# CITY OF ALBUQUERQUE

August 27, 2020

**Re: Pascetti Steel Building  
2114 Claremont Ave. NE  
Traffic Circulation Layout  
Architect's Stamp 08-10-20 (H16-D021)**

Based upon the information provided in your submittal received 08-26-2020, the above referenced plan cannot be approved for Building Permit until the following comments are addressed:

TCL
SHEET NO
A1.2

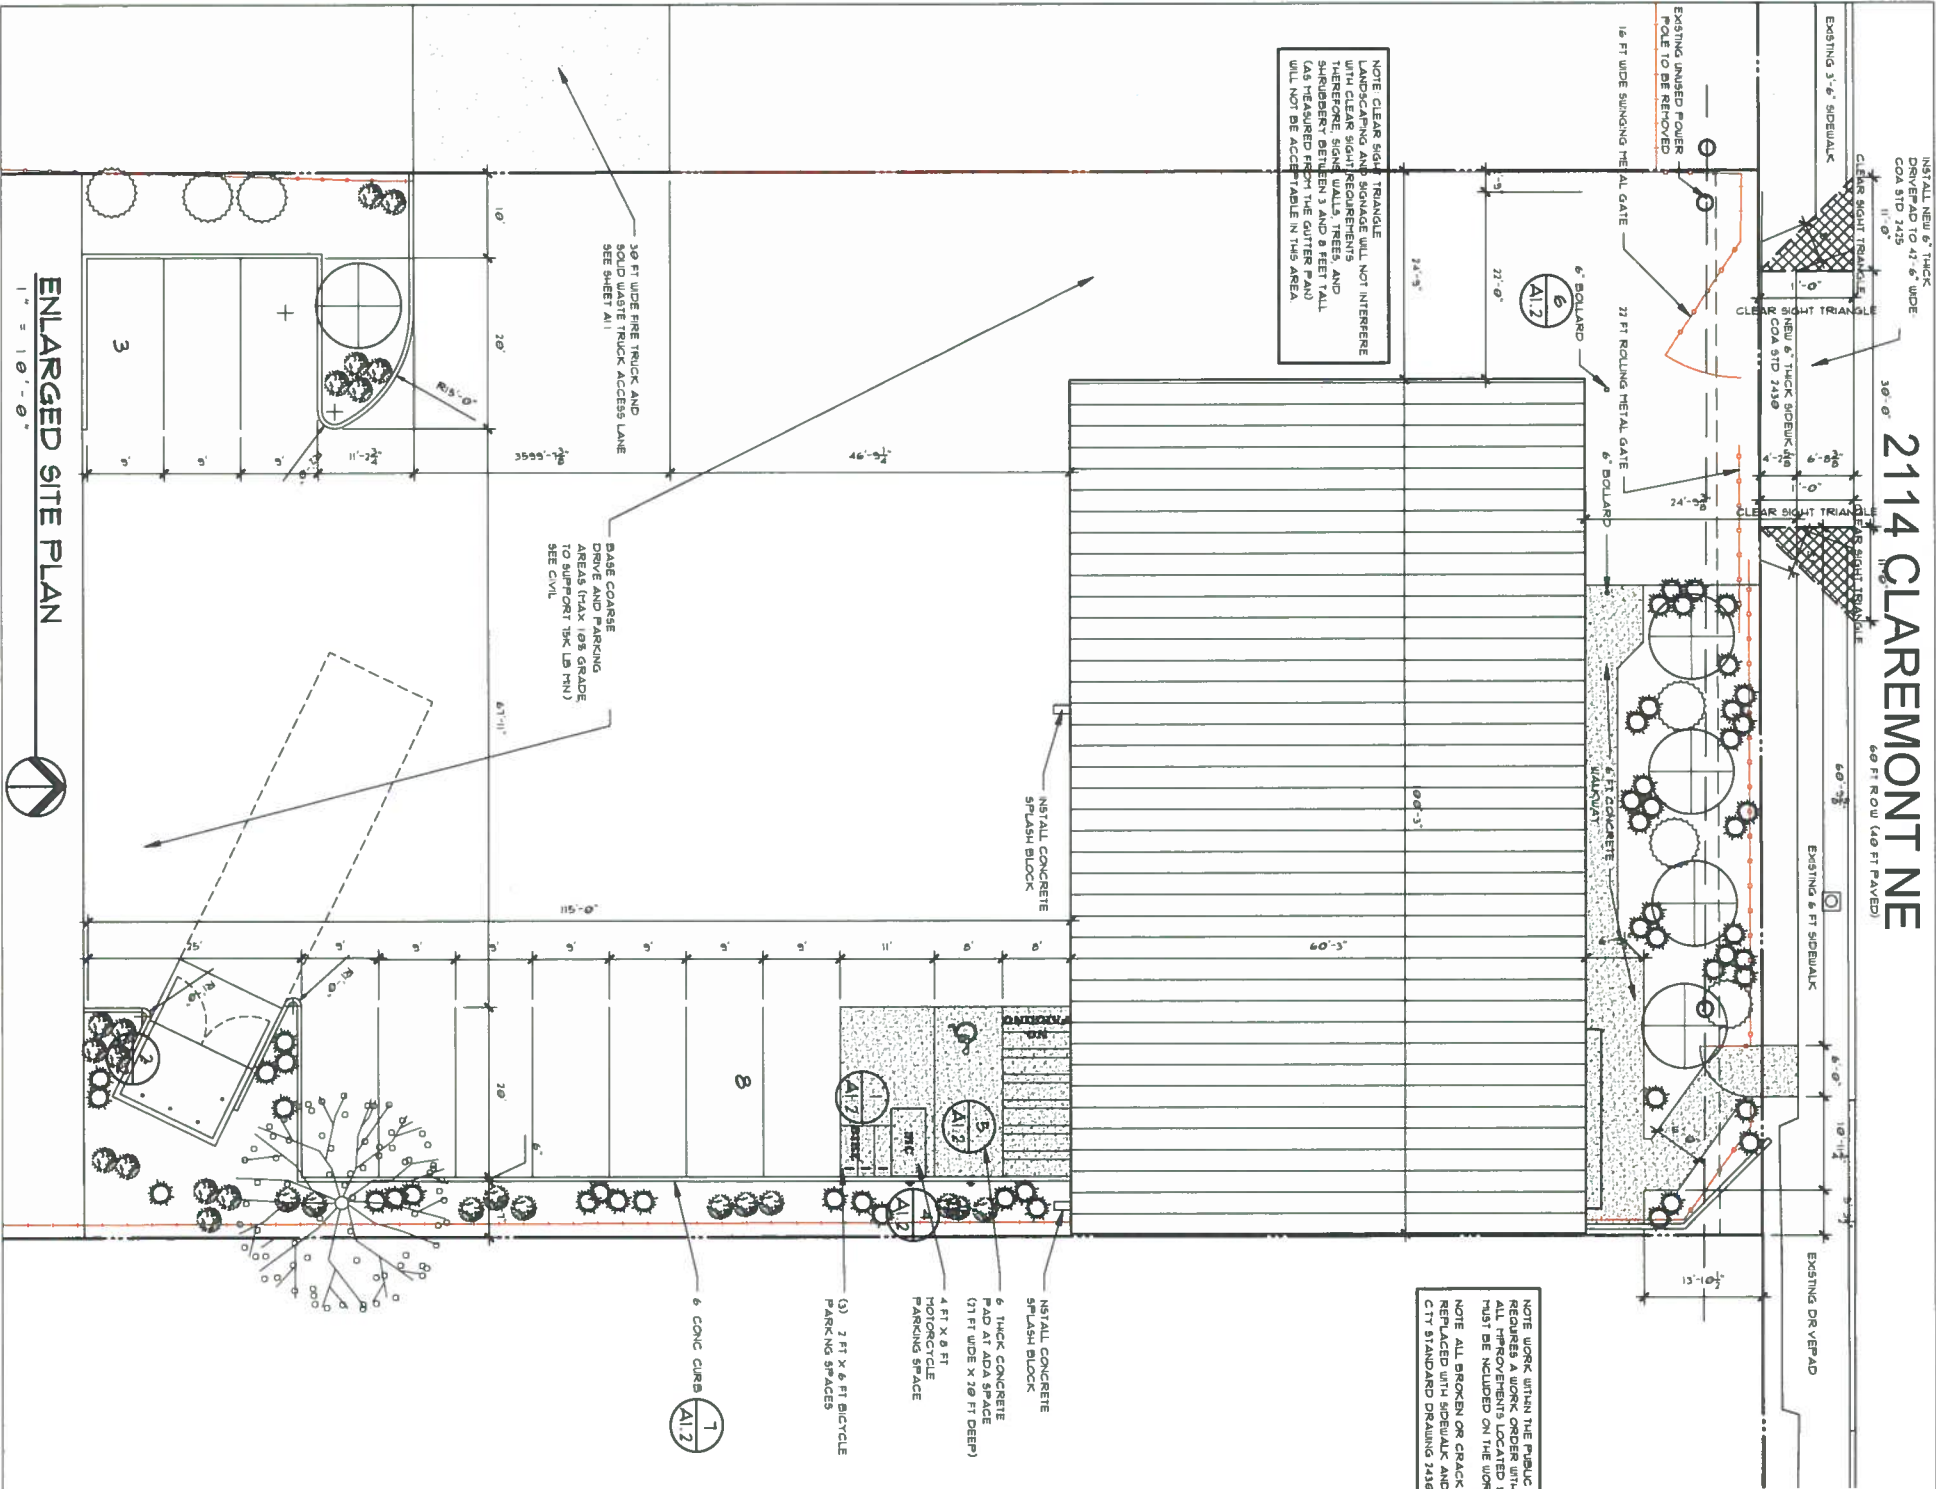
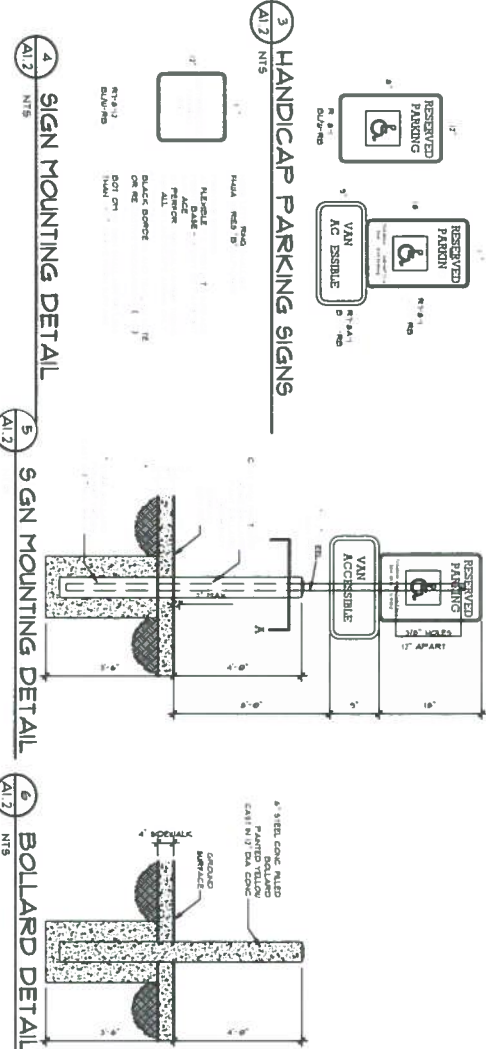
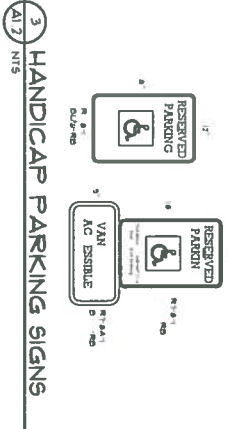
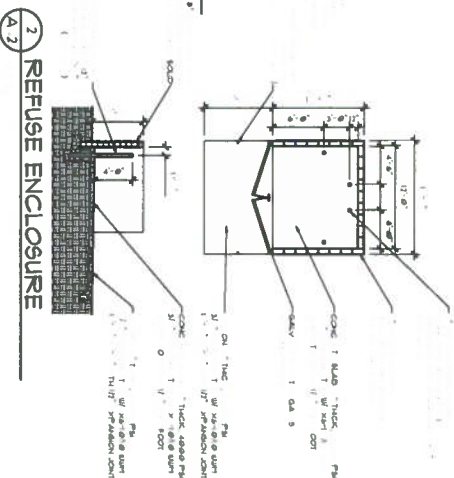
1. A **Shared Access Agreement** will be needed the drivepad portion of 2118 Claremont Ave. NE (Landowner Steve Koburi) that is on the eastern corner of 2114 Claremont Ave. NE.
2. For the proposed 30 ft entrance, a 4 ft ADA pathway will be needed across the entrance. Please provide design and detail to address this requirement.
